RFS

Your reference: SSD-54836993
Our reference: DA20230220000698-Response to
Submissions-2

State Significant Development - Response to Submissions - Residential Subdivision/Masterplan

Stage 2 Huntlee NSW 2335, 12//DP1137569, 11//DP1137569, 3//DP813163, 4//DP813163, 13//DP1137569, 146//DP1233016

LGA: SINGLETON & CESSNOCK
Locality: BRANXTON
& NORTH ROTHBURY
REDUCTION RATIO 1:750
LENGTHS ARE IN METRES

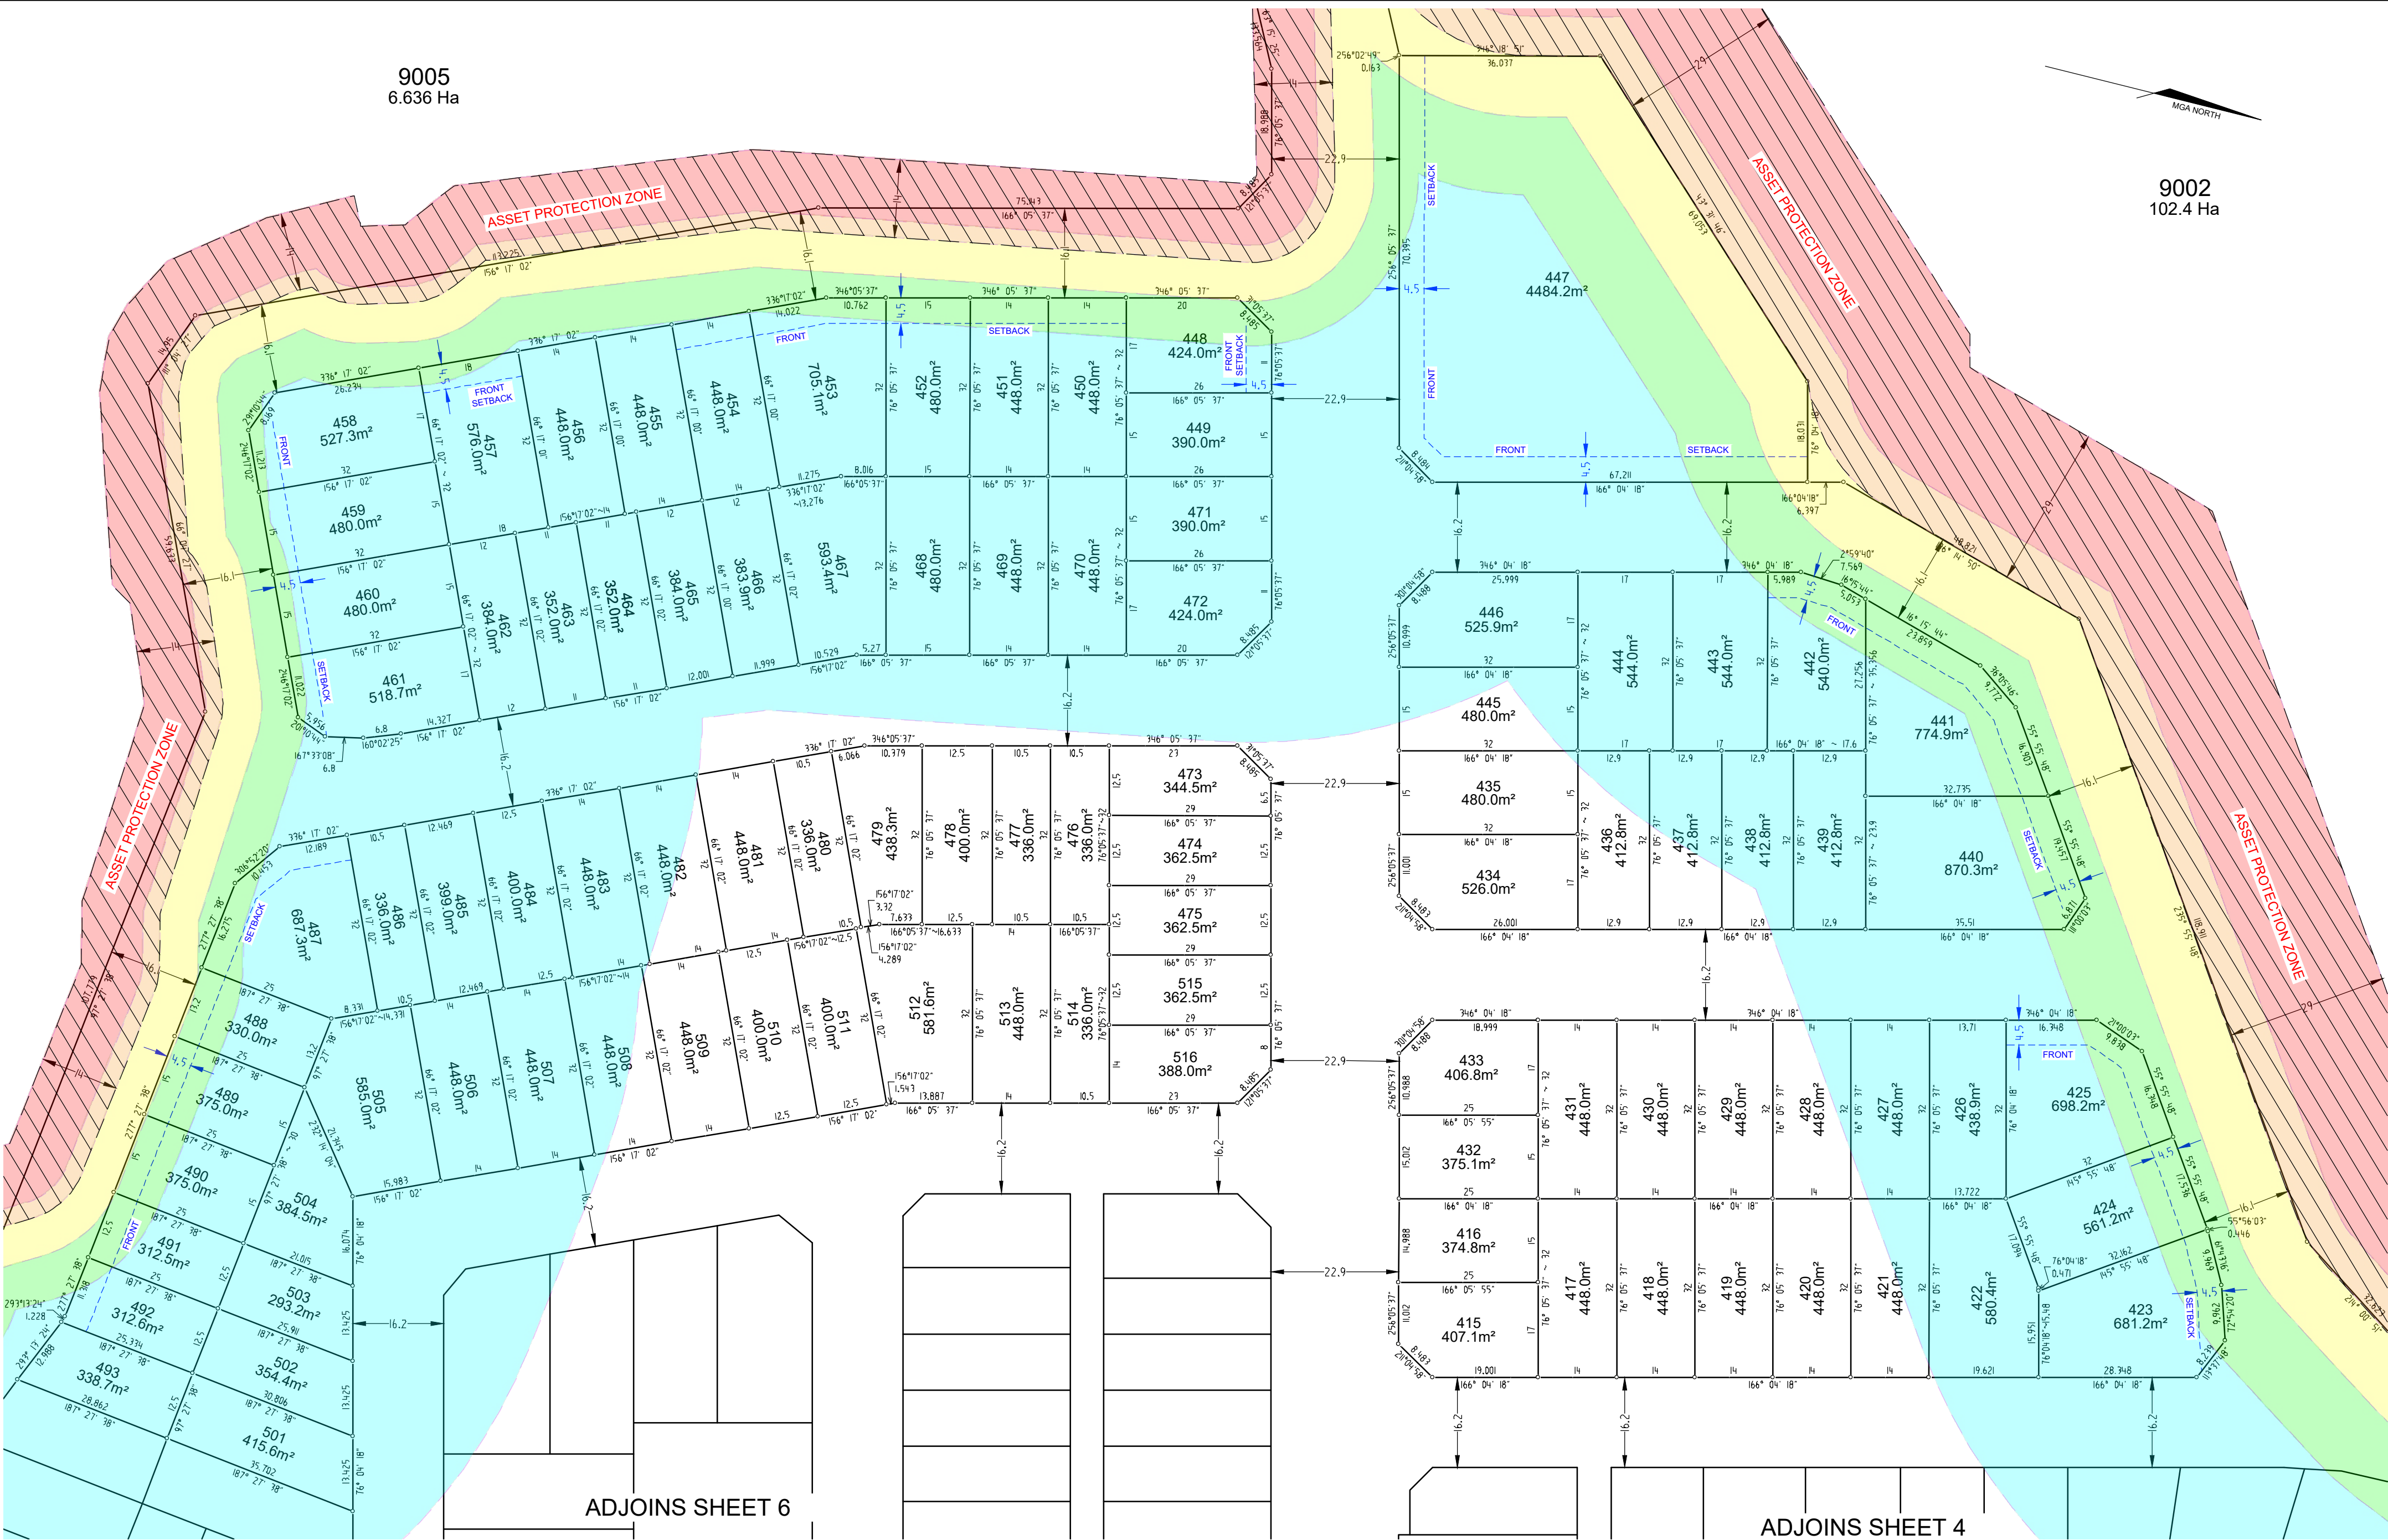
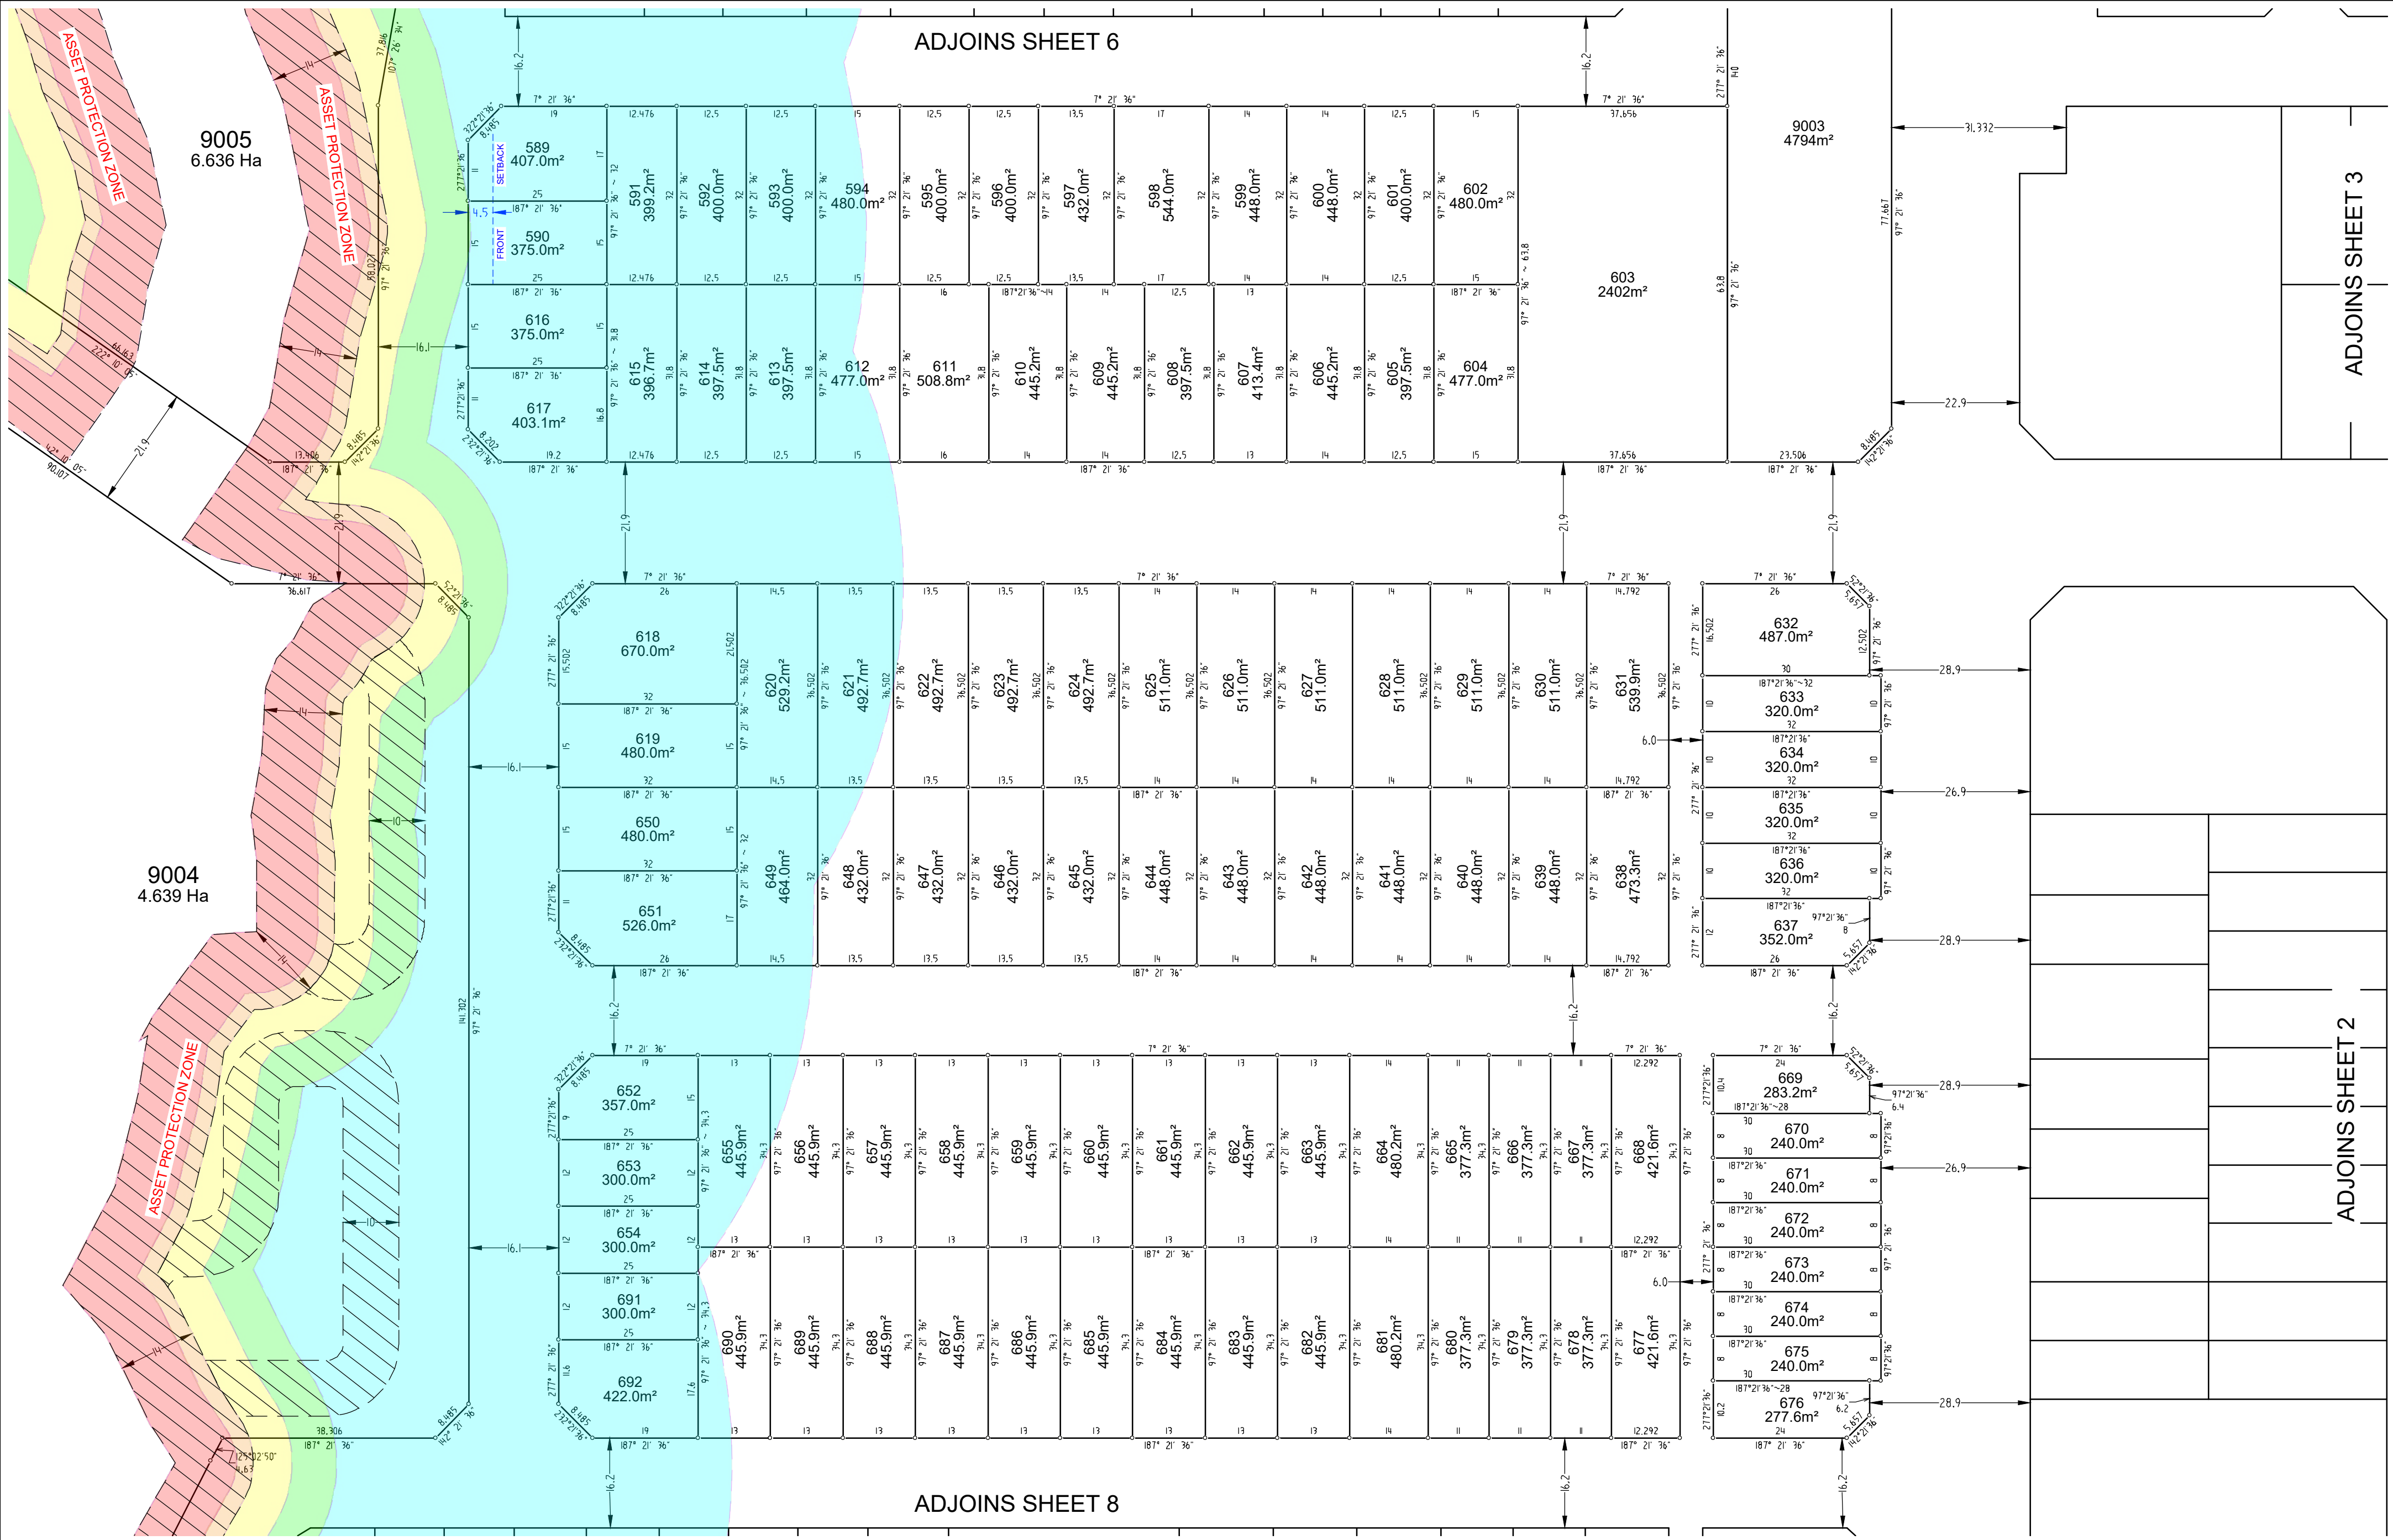
- With regard to Condition 3, the following matters need to be addressed for the bush fire attack level (BAL) Table and BAL-Plan provided in the bush fire report:

1. For clarity at the construction stage, the required setbacks are to be identified in metres on the BAL Plan as the distances for the BAL levels vary around the subdivision,

2. The BAL ratings applicable to each band of the BAL Plan are to be clearly identified on the plans,
 3. References to BAL-12 throughout the BAL Table must be amended to BAL-12.5,

- Review BAL Table for duplication of lot no. 799-806 (Sheets 6 & 7).
